Application for removal or variation of a condition following grant of
planning permission. Town and Country Planning Act 1990.
Planning (Listed Buildings and Conservation Areas) Act 1990

Erection of 2 No. single storey units, use class A1 (shop) and B1c (business) and creation of a new rear access.

96858/FUL/19 Erection of 2 No. retail units A1/B1c and new rear access

21A
GROUND FLOOR
Postal delivery point

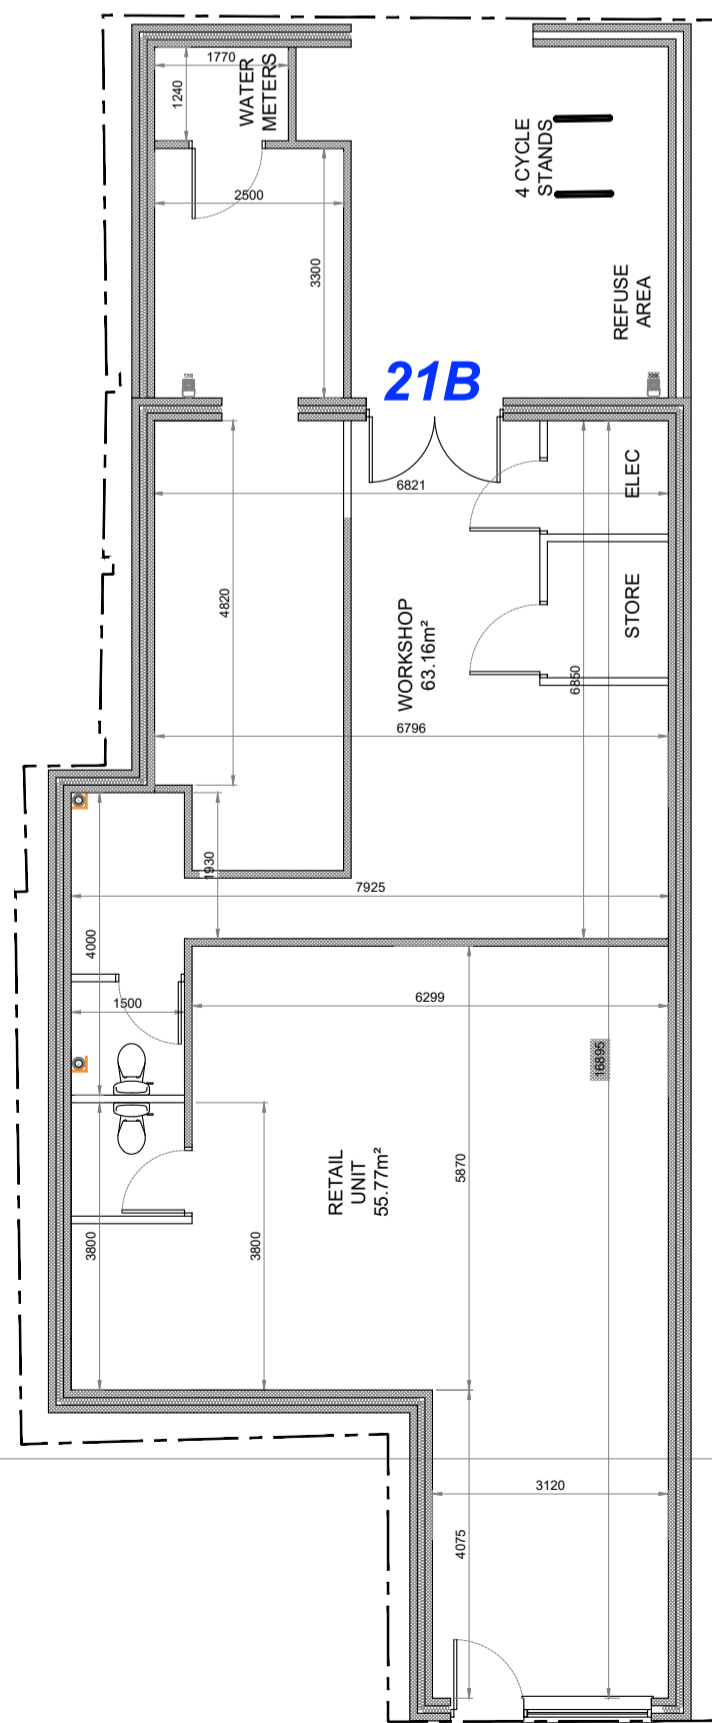
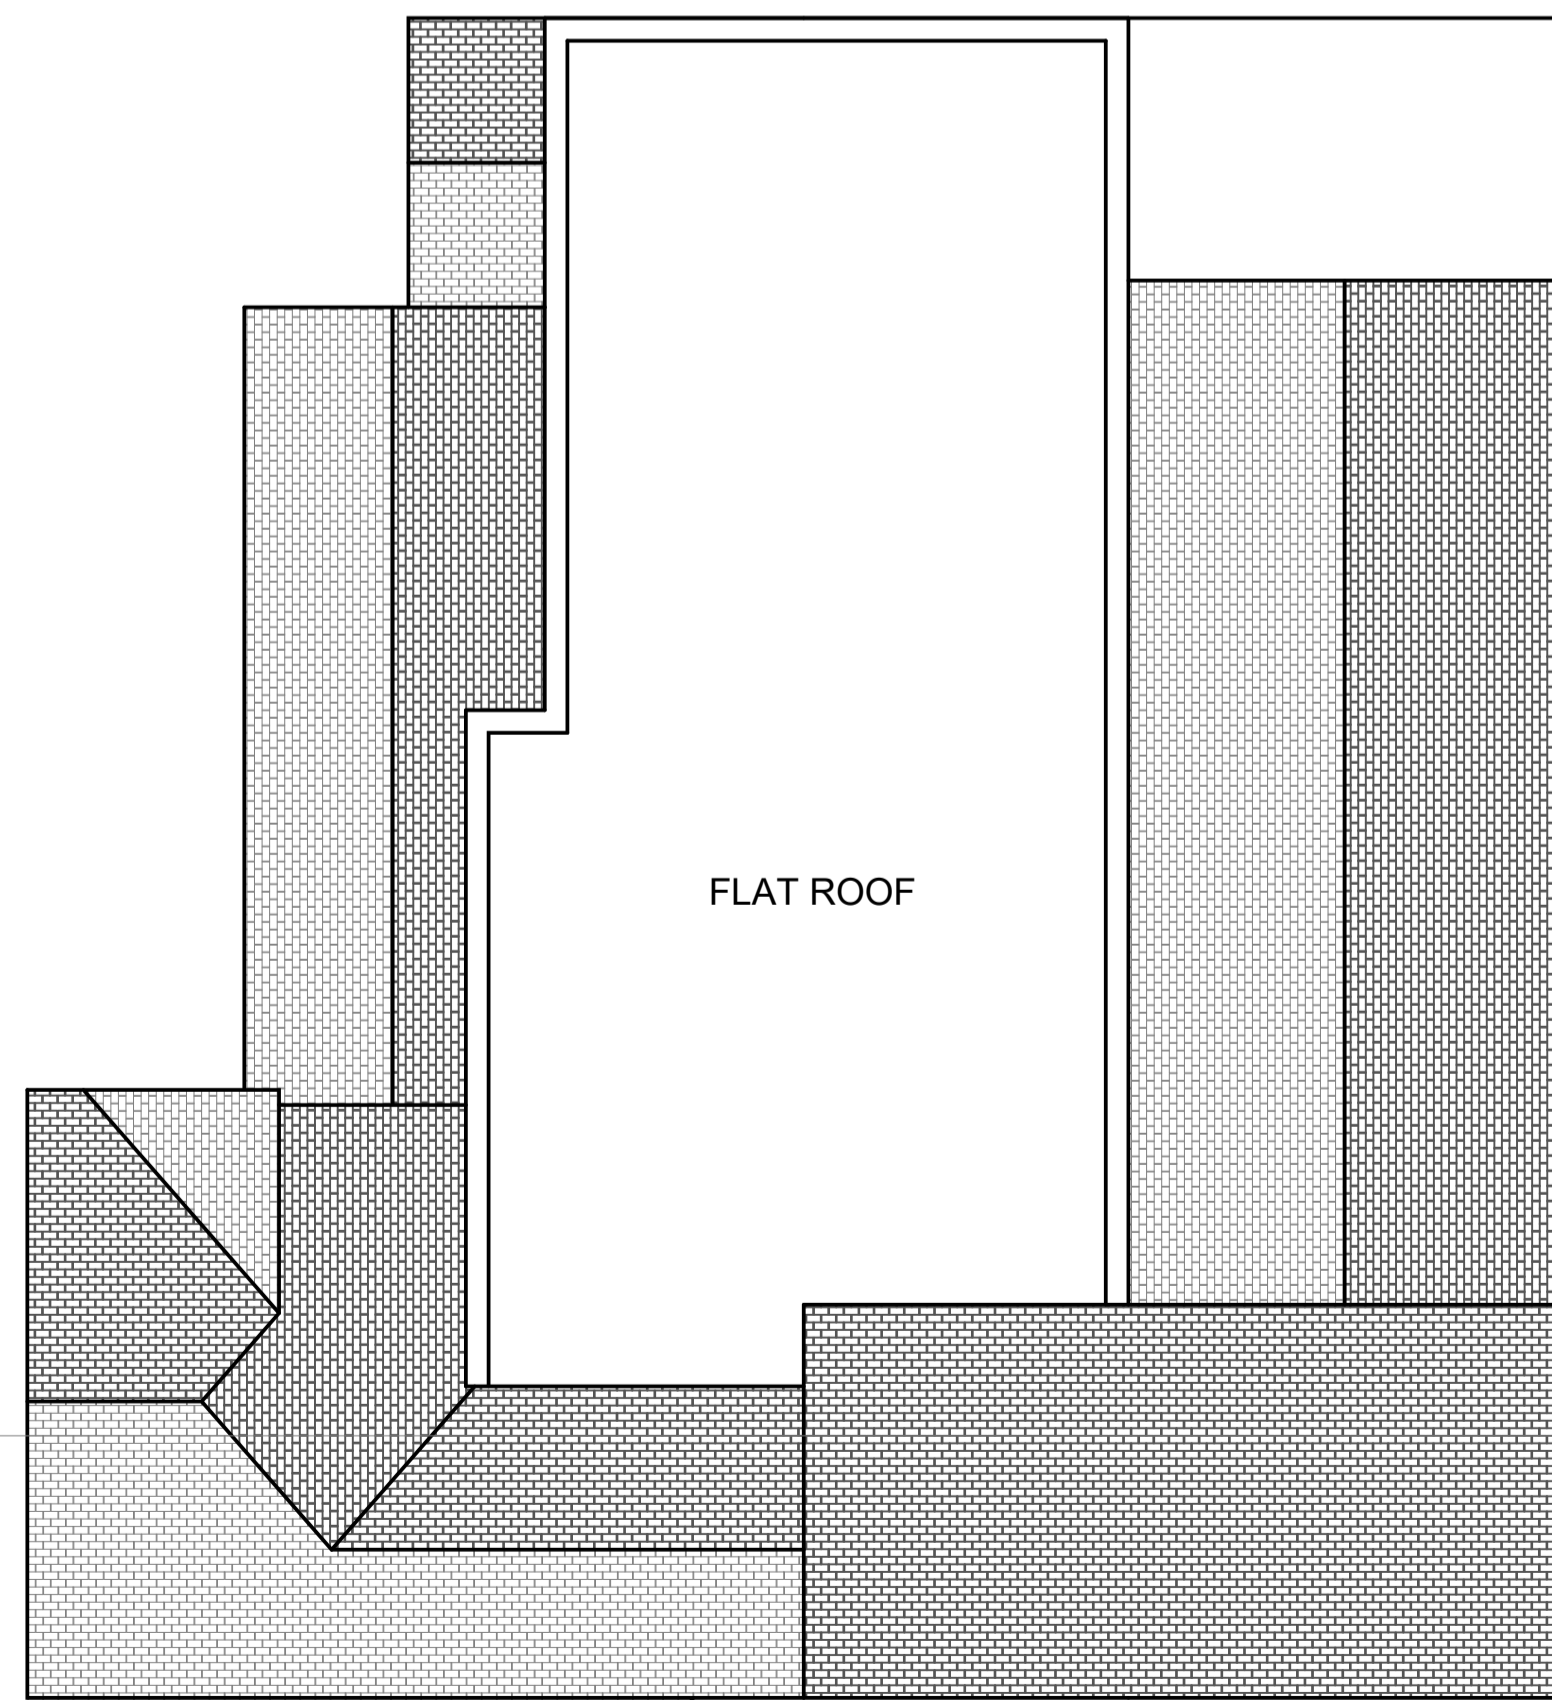
We have resolved the issue as far as the shop is concerned by relocating the interior dividing wall further into the workshop - giving the shop an area of 55.77m² (600sqft).

However, this has reduced the workshop to 45m² which would be too small to have the desired 5 employees.

As a solution we propose to use a small area (18m²) within the existing rear covered area to extend the workshop - this would not impact on the planning conditions regarding the 2 cycle rack and bin area, as shown in the plan.
